2022/0709

Erection of 1 no. detached dwelling

Land adj. 15 Beever Lane, Gawber, Barnsley, S75 2RP

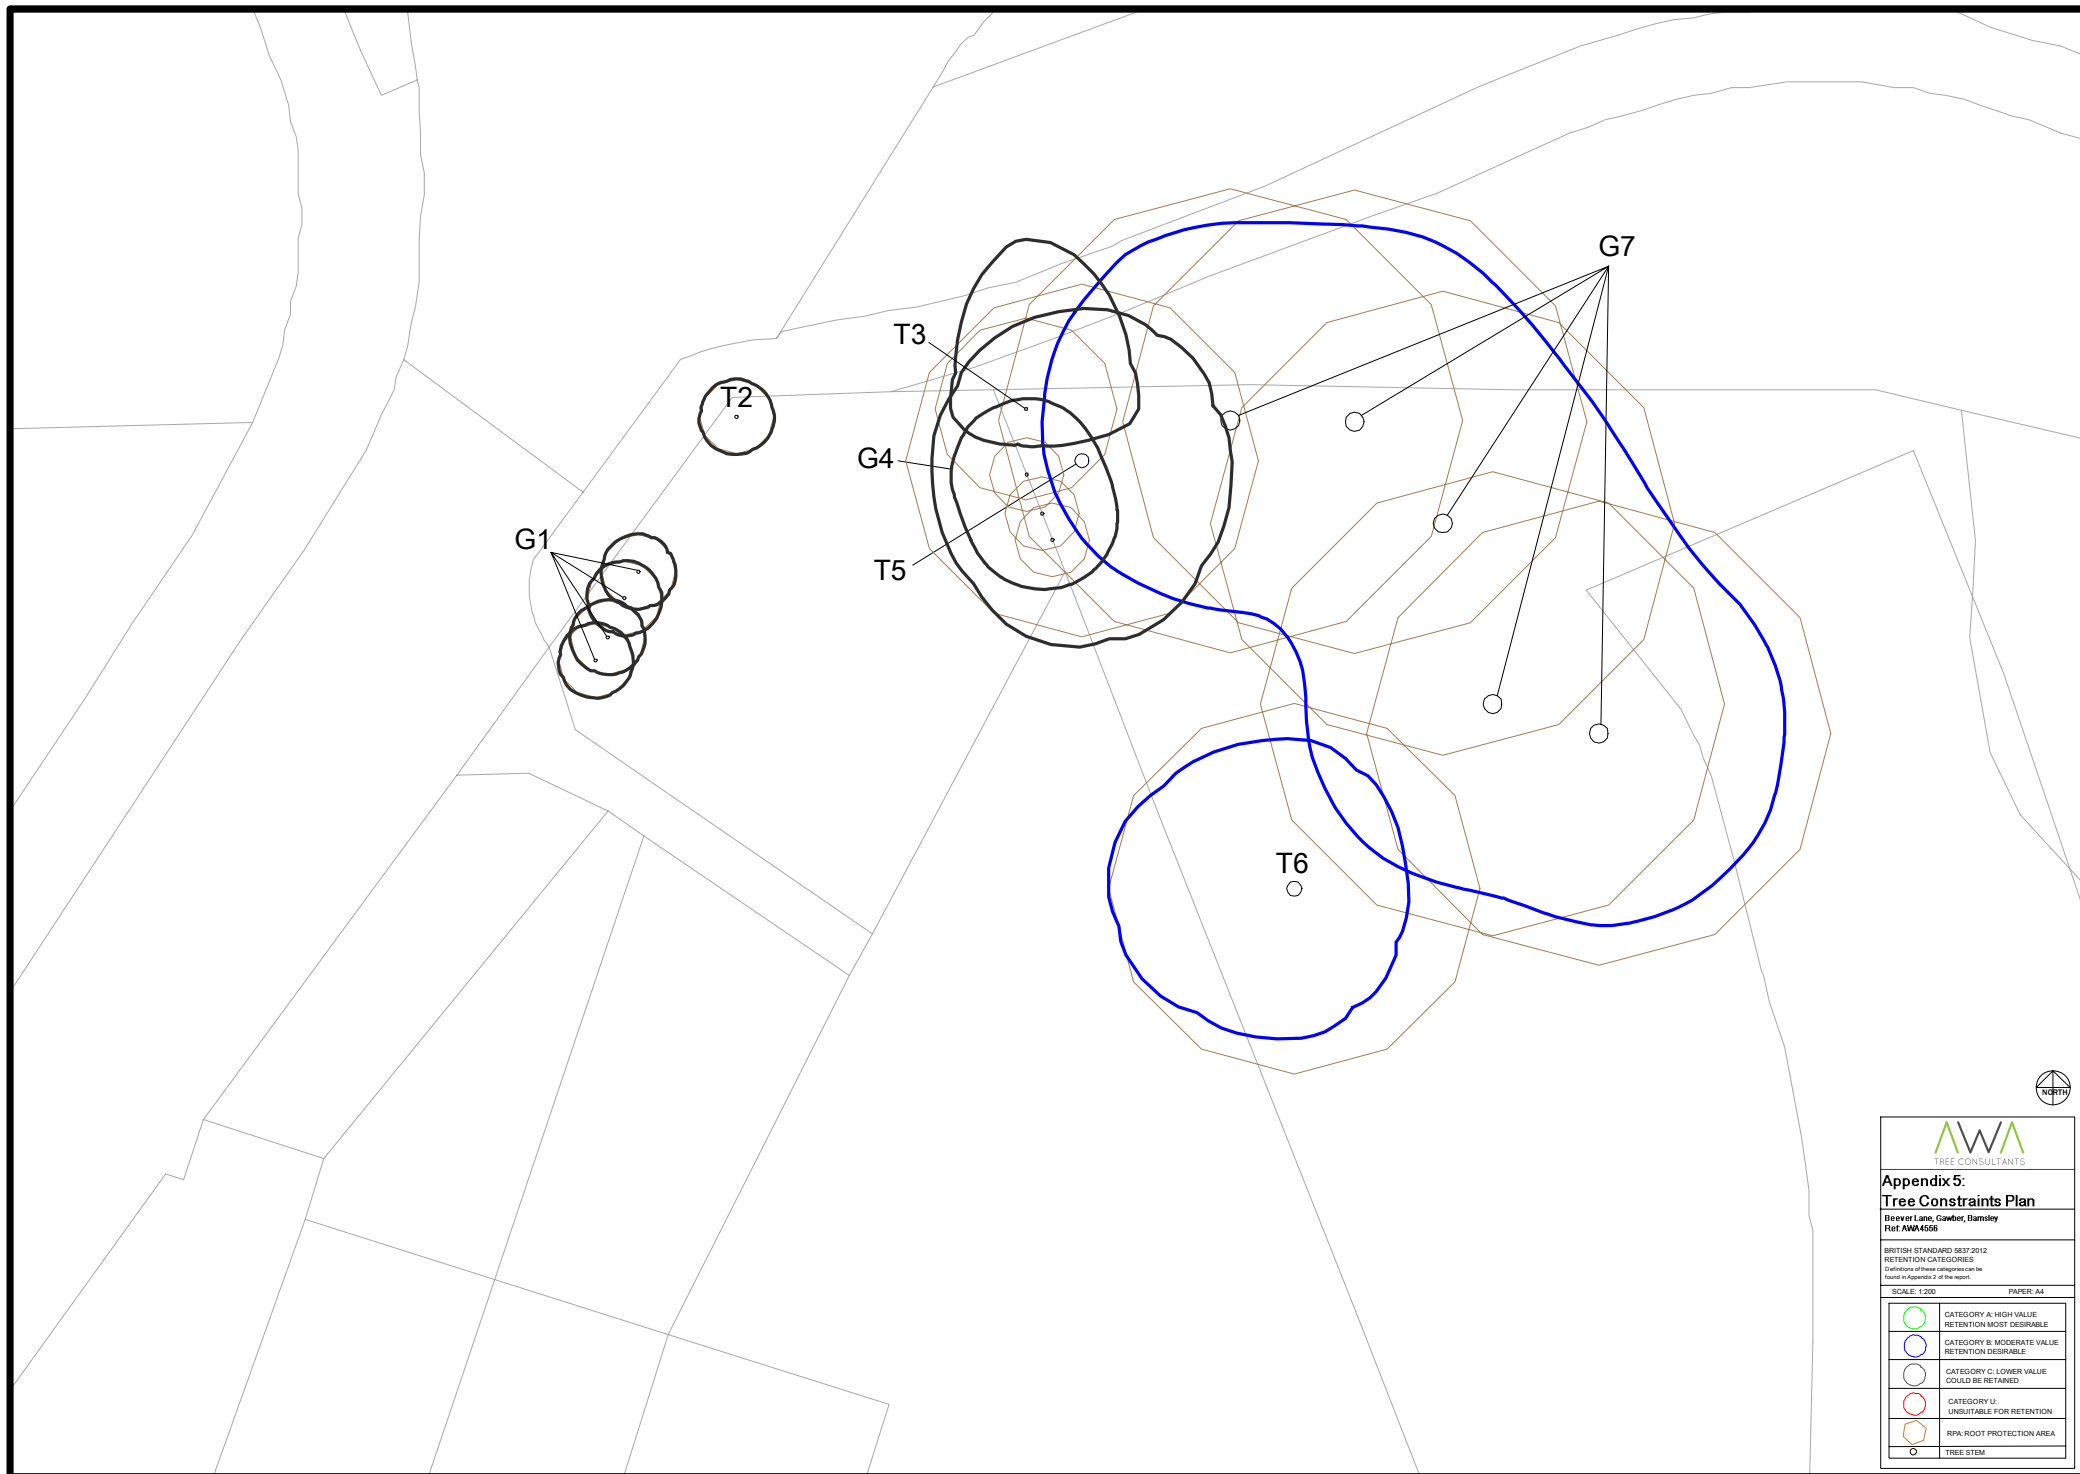
The proposed development requires the removal of a hedgerow on the South-Western corner of the application site (outlined as G1 on the Arboricultural Report). These have been identified as Category C within the report in a fair physiological and structural condition, with no works required in current site context. The report indicates in section 3.4.3 that *'if required by the development proposals, occasional lower value, retention category 'C' trees, tree groups and hedges could be removed, and replacement planting would largely mitigate their losses'*. No specific landscaping plan was initially proposed by the developer with an extremely brief supporting document which simply reads: *'No Landscaping is proposed as part of the application but a condition can be imposed requiring planting within the garden area.'* It is feasible for the Local Planning Authority to place such a condition requiring replacement planting but in this case, the site is of a small nature of the site, the layout of the dwelling/garden area and the existing trees, that a landscaping scheme would not be feasible or achievable to mitigate the loss of the hedgerow, or indeed the impact on other trees in the site/immediately adjacent.

The Arboricultural Report shows the presence of several trees in very close proximity to the site, on the boundary line but located in the neighbouring property not under the ownership of the applicant. Several of the tree canopies overhang into the application site, especially into the area to the North of the dwelling which would form part of the garden area for the proposed dwelling. The Tree Officer has been consulted and not raised any overriding concern that the construction of the dwelling would have a detrimental impact on the trees. However, did raise concern that the proximity of the development to these trees could lead to potential future conflicts with the trees and the tree owners, particularly as the trees still have a significant scope for future growth.

It is considered that the development of the plot is not in line with the SPD for Trees and Hedgerows as it seeks to develop a small plot which is in very close proximity to mature trees and will place undue pressure on the existing trees, creating conflict with the future residents and tree owner/s. This will be accentuated by the fact that the trees will overhang into the garden area of the plot, very likely result in leaves dropping into the garden area and overall danger from branches falling in high winds. The close proximity will very likely lead to pressure to significantly prune or remove the adjacent trees completely which will have a detrimental impact on the character of the area. It is clear that the layout of development has not been designed with due respect for the adjacent trees and the existing trees have not dictated the development.

PROPOSED

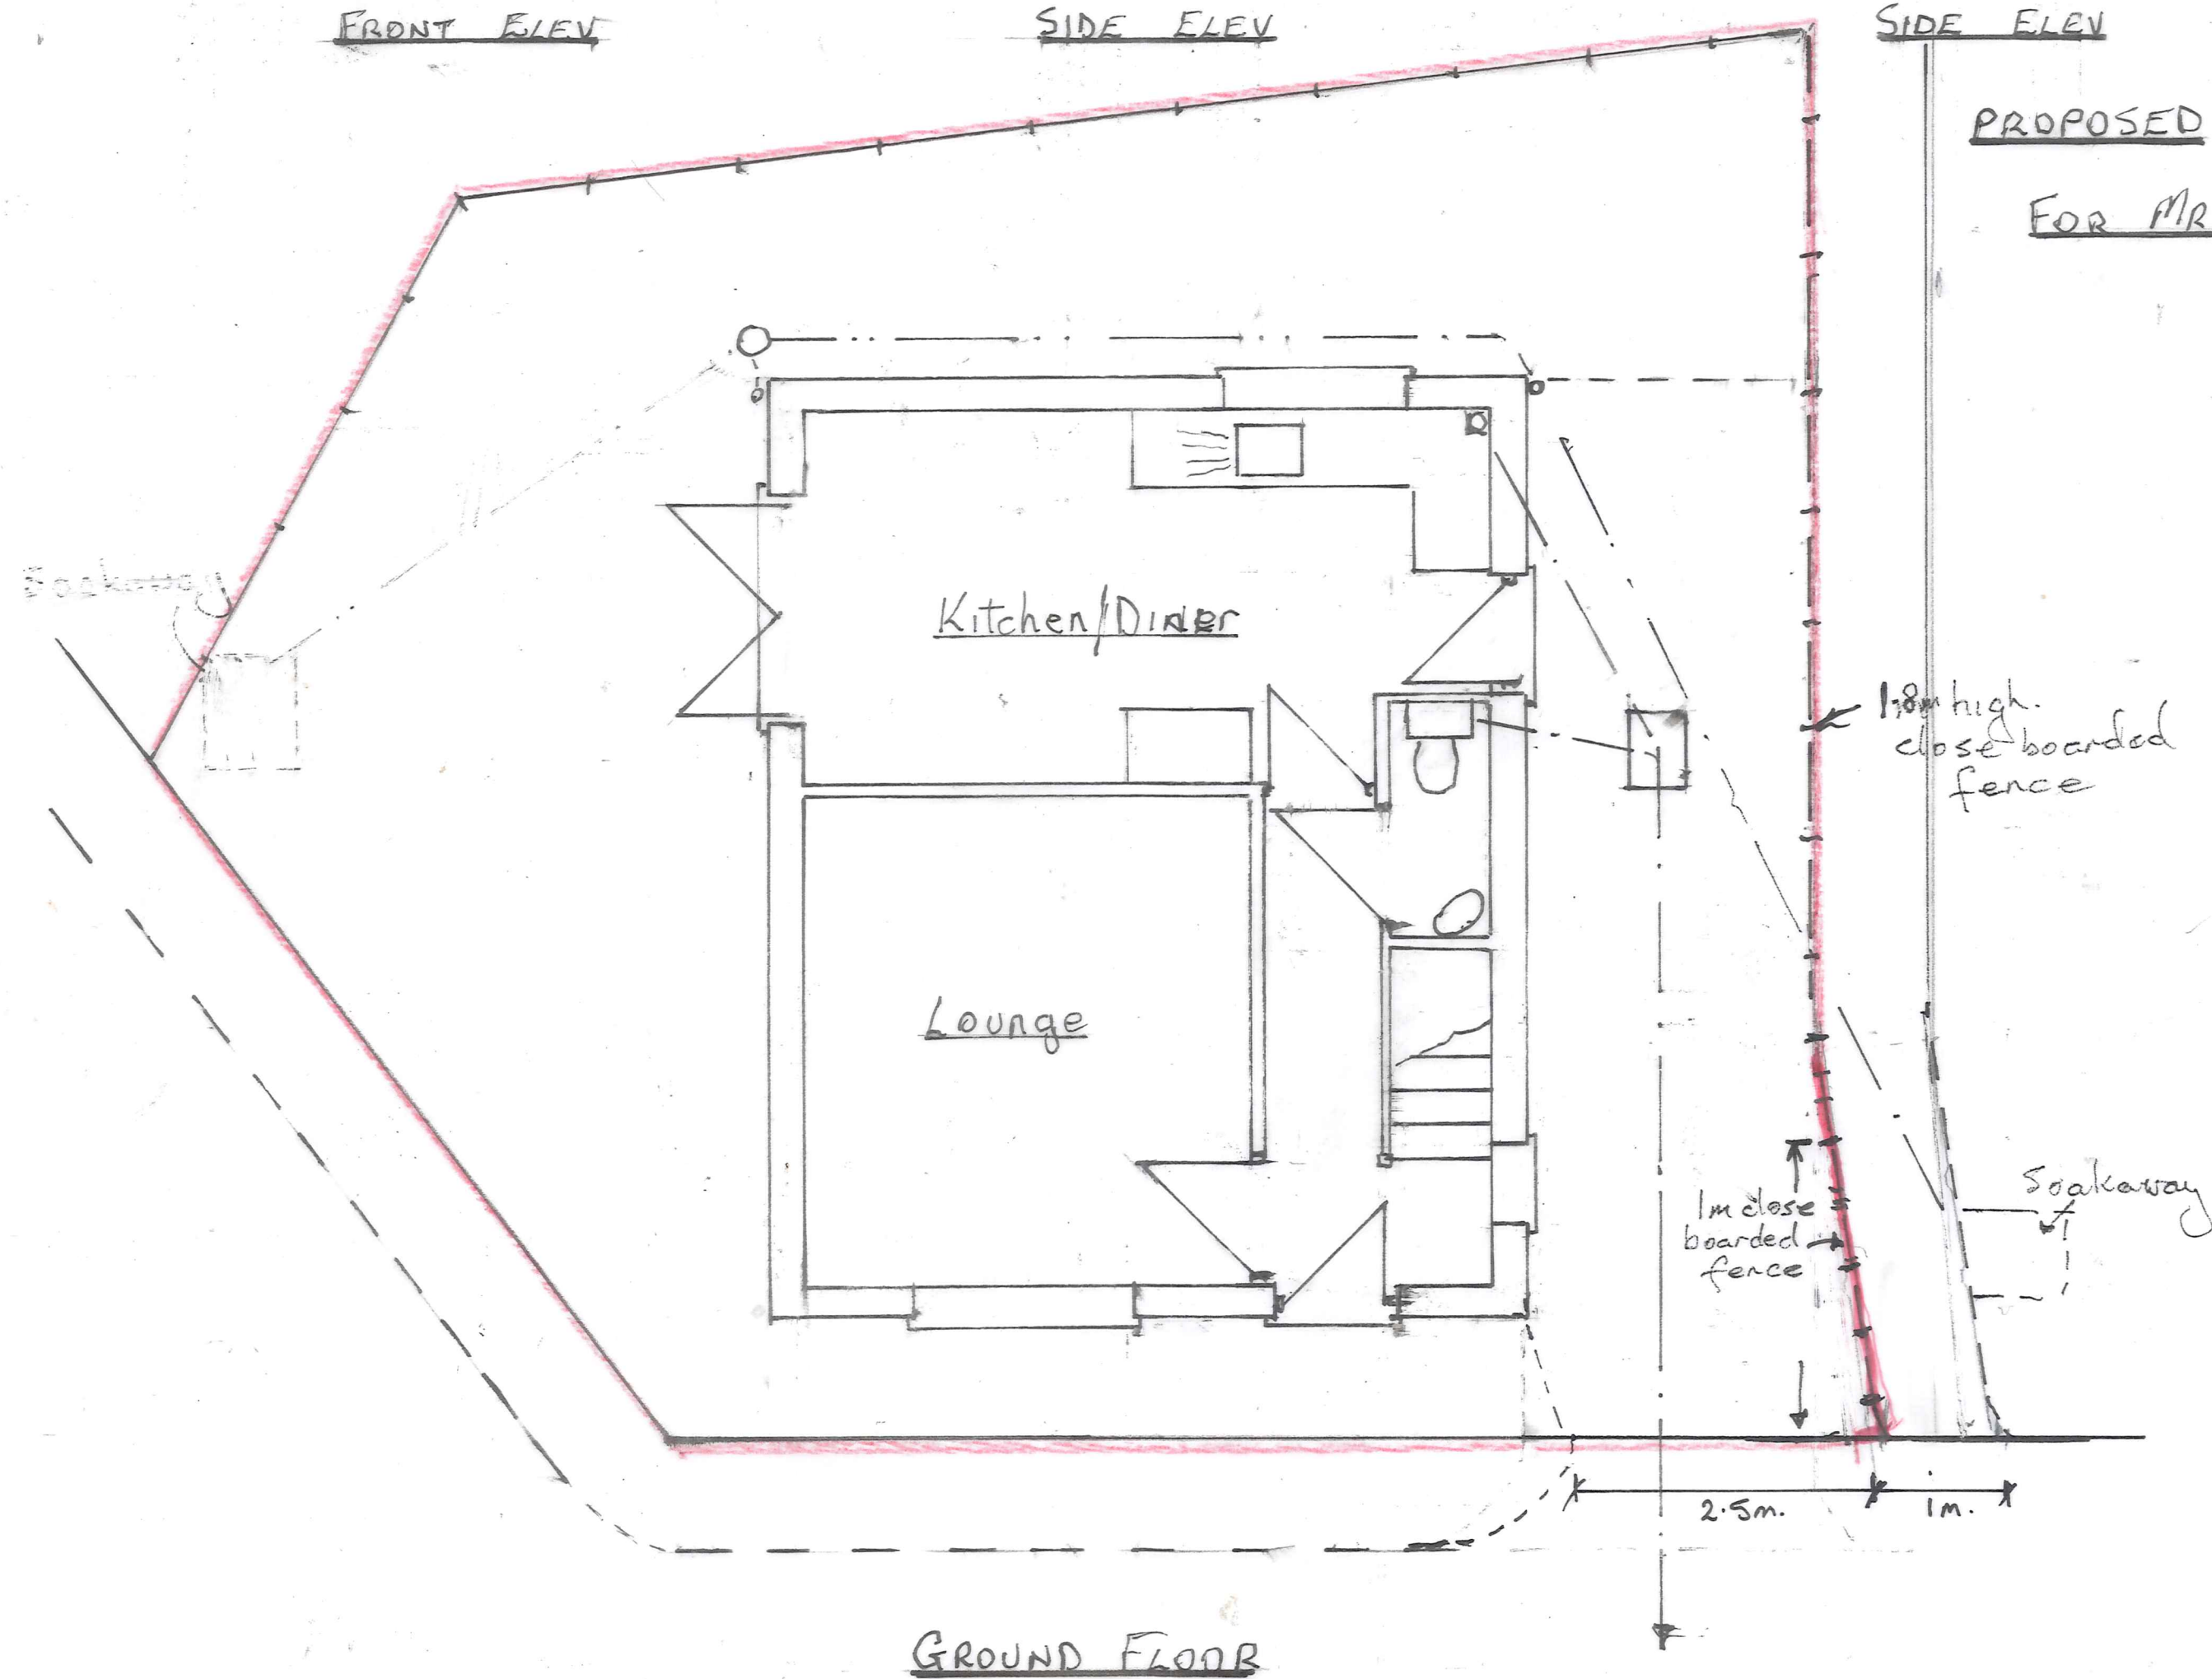
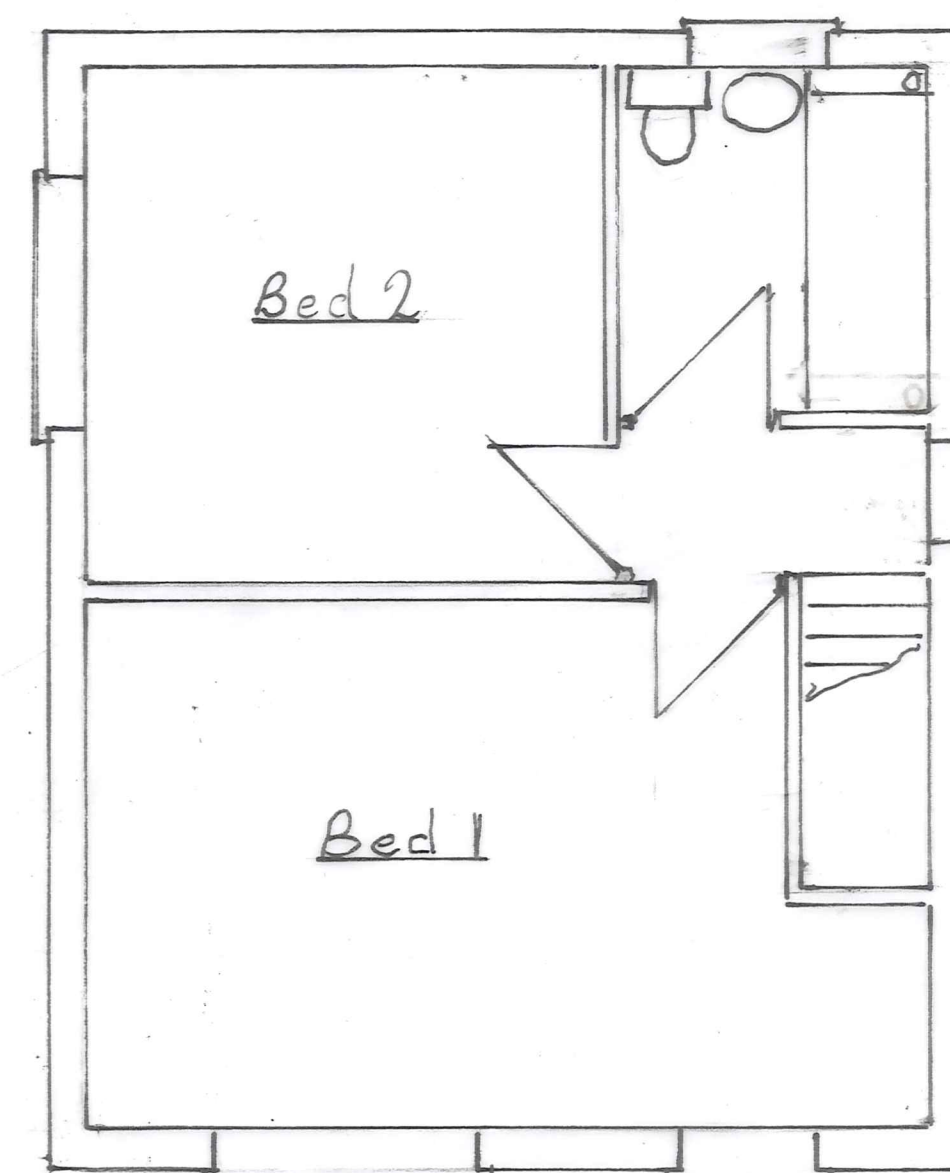
Initial response – The proposed driveway appears to have a width that tapers down from 2.3m to 2.1m which is insufficient. In accordance with Section 4B.1.1.19 on page 135 of the South Yorkshire Residential Design Guide, this driveway needs to have a minimum width of 3.3m as it also serves as a pathway to the house. The pedestrian access to the front of the adjacent properties should be accurately shown on the proposed site layout plan as there seems to be a discrepancy between the red line boundary and the proposed vehicular access. The red line boundary has a distinct chamfered corner and with the proposed driveway positioned hard up against the southern boundary of the site this would mean the vehicular access would use part of the existing pedestrian access – an area which is outside of the red line boundary. The applicant should clarify whether they have rights of access over this small triangular piece of land? (Identified by the 'crazy paving' surfacing when viewed on Google Street view). At the vehicular access point, the site layout plan shows radii to both sides of the access along with a continuous kerb line. The existing footway and kerb line end before the southern side of the proposed access, the applicant should therefore clarify whether it is intended as part of the proposals to extend the footway along/past the site frontage. If not, the plan should be amended so as to accurately reflect the proposed layout. Should the applicant wish to address the above raised issues I shall be happy to provide further comments as necessary.

The dwelling has windows on the rear (West) and Northern side. The proposed dwelling is two storey but the only window on the rear elevation is a bathroom window and therefore the 10m separation distance does not need to be maintained. Rather, there is a bathroom window at first floor level on the rear elevation, which will be conditioned to be obscure glazed and the windows serving bedroom 2 faces North into the proposed garden area of the plot. These do not lead to direct overlooking into neighbouring properties. Bedroom 1 contains 2 x windows on the front elevation at first floor level which face onto Beever Lane but the nearest adjacent properties are c.45m to the West which vastly exceeds the minimum 12m separation distance expected between front-facing habitable room windows.

Further, there are also significant concerns regarding the lack of outlook offered from the property with habitable room windows located on the North (Side) and East (Rear) elevations facing into the small amenity area at a very close distance to the respective boundary lines. There are 2 x habitable room windows located on the North elevation which are 5m at the furthest point from the respective adjacent boundary line and the secondary window serving the kitchen/diner on the East (rear) is 2.2m from the Eastern boundary line. The end result will be that residents of the dwelling will face out onto a small amenity area at a very close distance which is heavily covered in trees/other vegetation, offering little outlook. This is illustrated on the screenshot below:

Second response – With regard to the amended plans (submitted on 06/01/2023), the alignment of the path leading to nos. 9-15 Beever Lane has now been amended to accurately reflect the route of the existing access rights. This has resulted in a vehicular access/driveway of adequate 2.5m width to be provided between the end of the footway on Beever Lane and the path providing the pedestrian right of access. The proposals are therefore acceptable from a highways point of view, subject to conditions and an informative note.
